**Subject: Independent Fire Protection Review for Cumberland County Civic Center Renovations**

A review has been completed of the fire protection construction documents (CD) set, dated 21 January, 2013, which has been developed to support renovation efforts at the Cumberland County Civic Center in Portland, ME. The documents reviewed included both the fire protection demolition and design drawings, along with the design specifications for the various fire protection and life safety related systems.

4/12/2013 3:26:03 PM C:\Users\jlmahar\Documents\375700 - CCCC Electrical_1\jlmahar.rvt

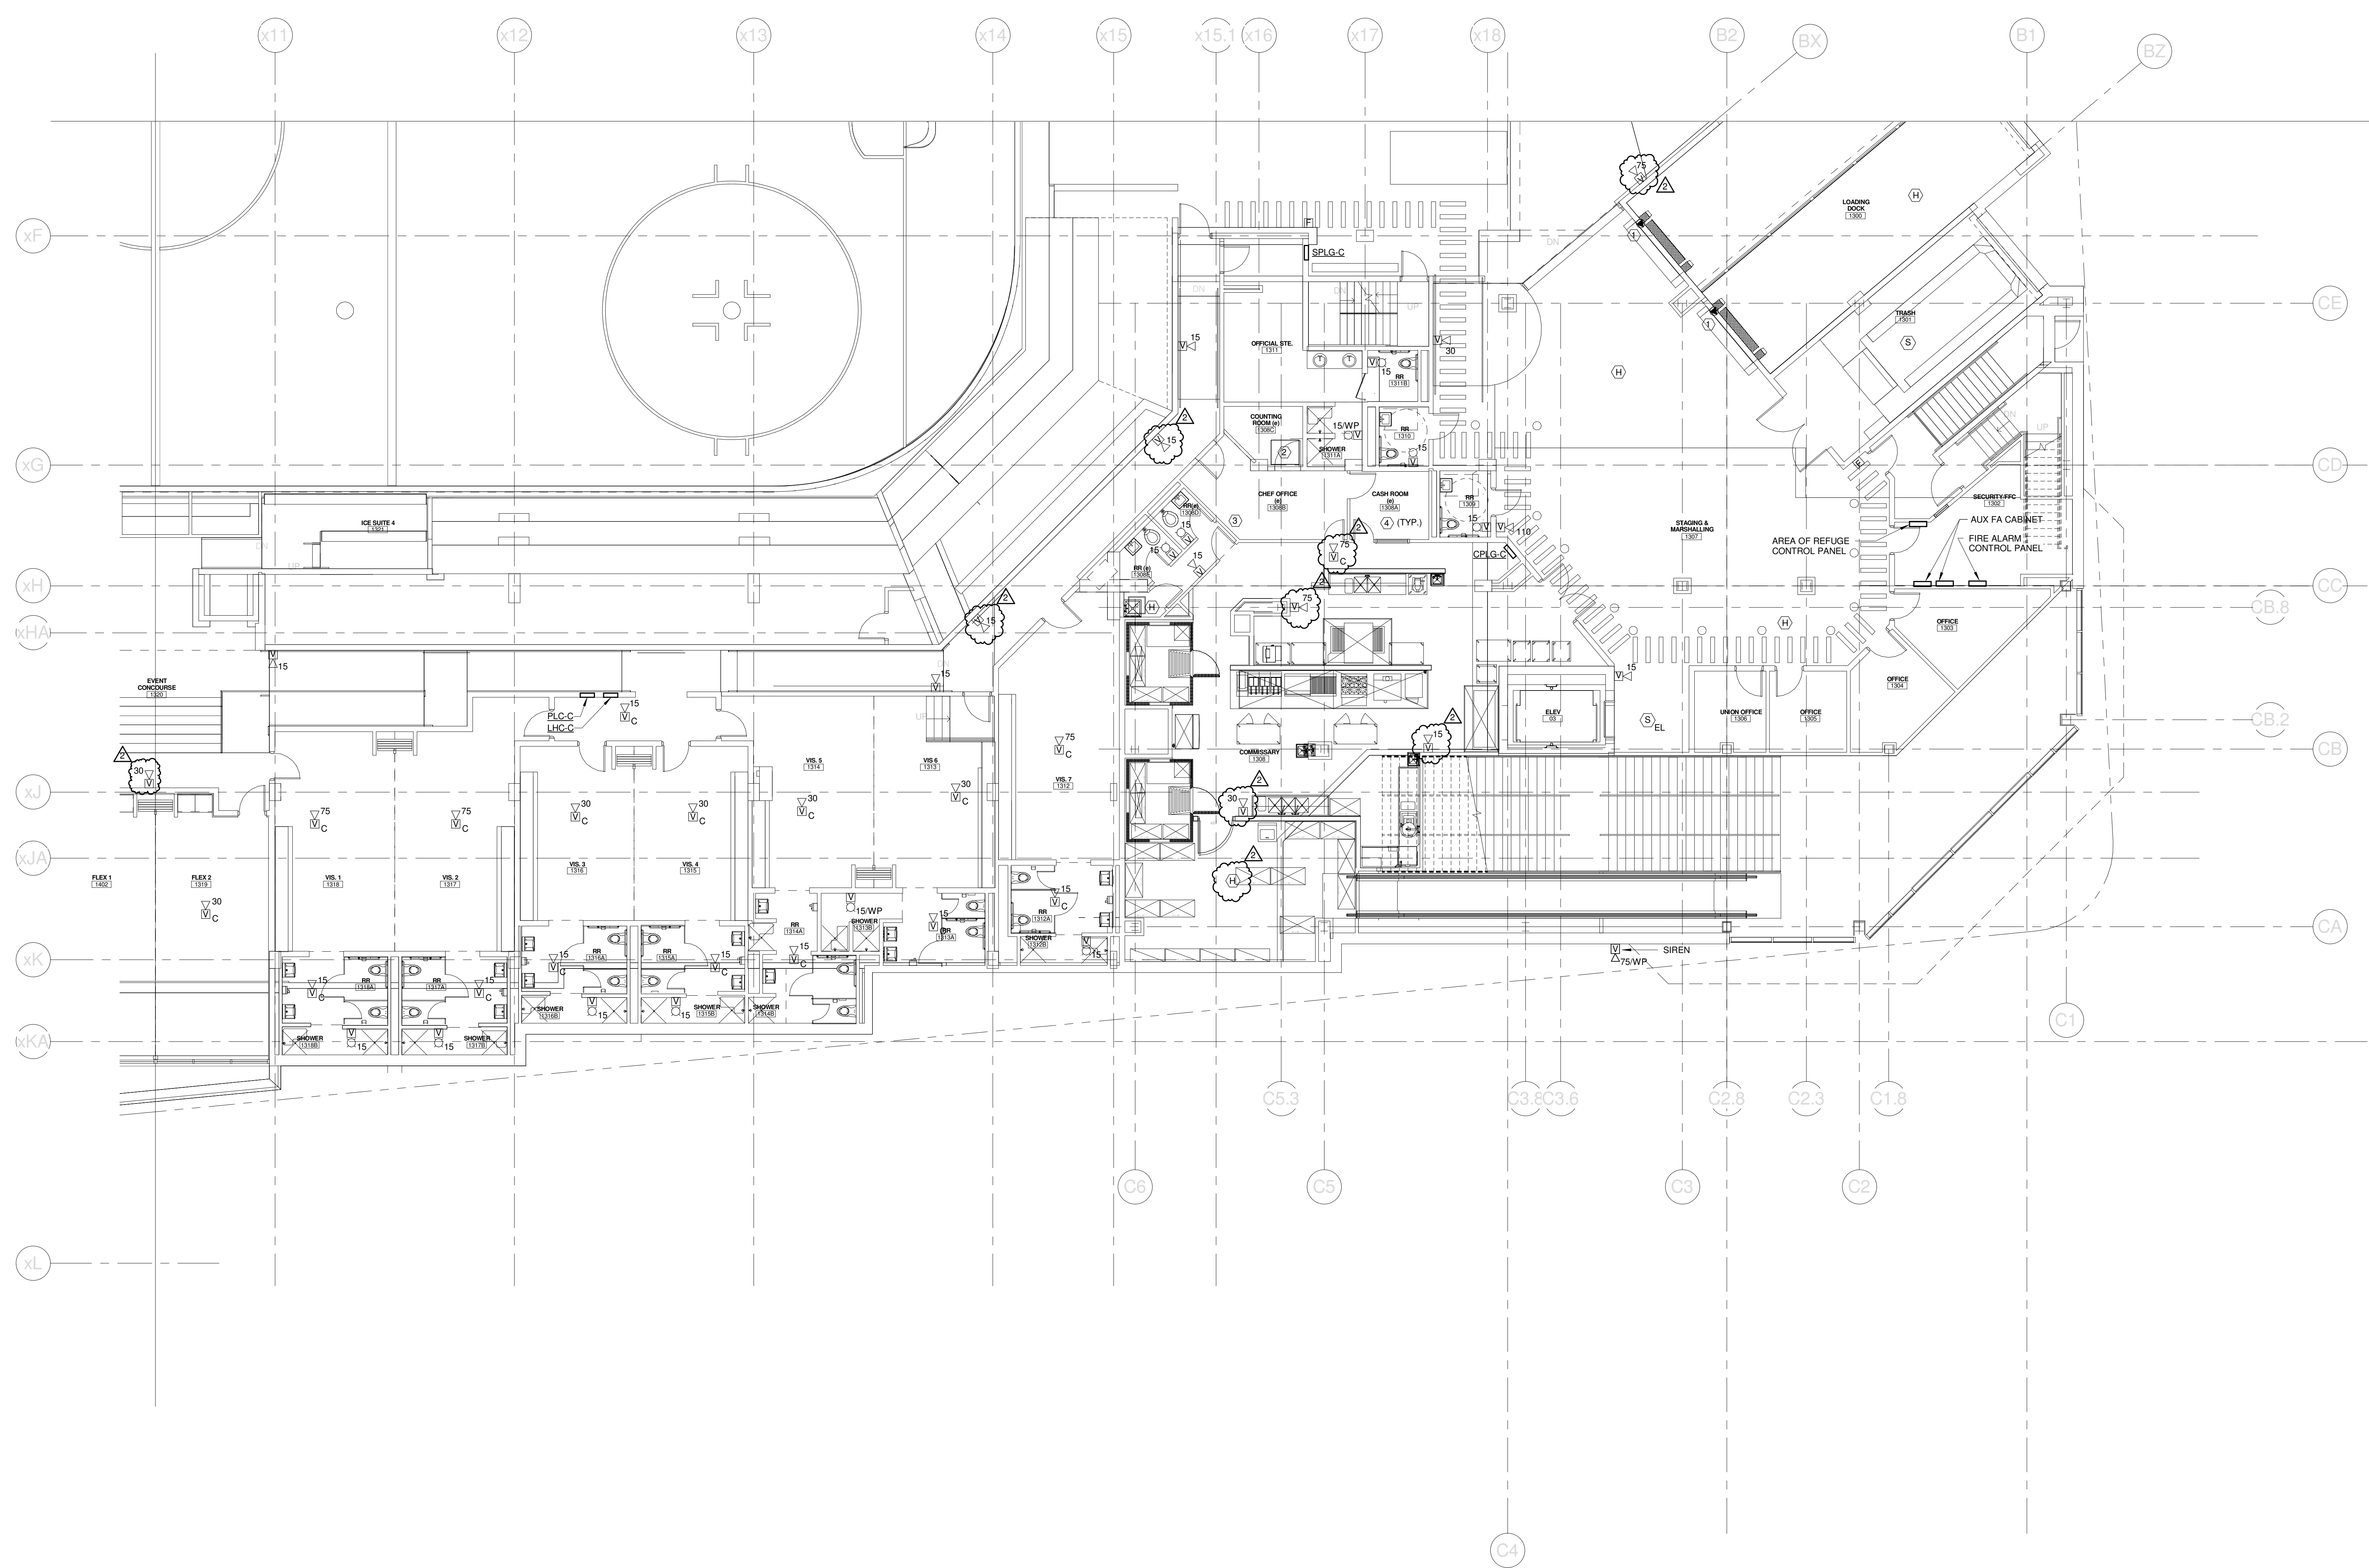
The fire alarm system components are being included with the electrical drawings. This makes a review of this system very difficult. The fire alarm system design should follow standard drawing standards and be depicted separately, using the standard drawing naming/numbering scheme (FA series). A review of the electrical drawings that depict the fire alarm system components indicates there are numerous problems, both from the lack of devices as well as devices being depicted in areas where they are unnecessary. For example, numerous smoke and heat detectors are shown in areas where they are not needed, such as in corridors and closets. Additionally, symbols are used on the drawings that are not depicted in the legend. The fire alarm system design drawings must be reviewed in detail to not only ensure that they provide a code-compliant system, but one that does not require numerous components where they are not needed or required.
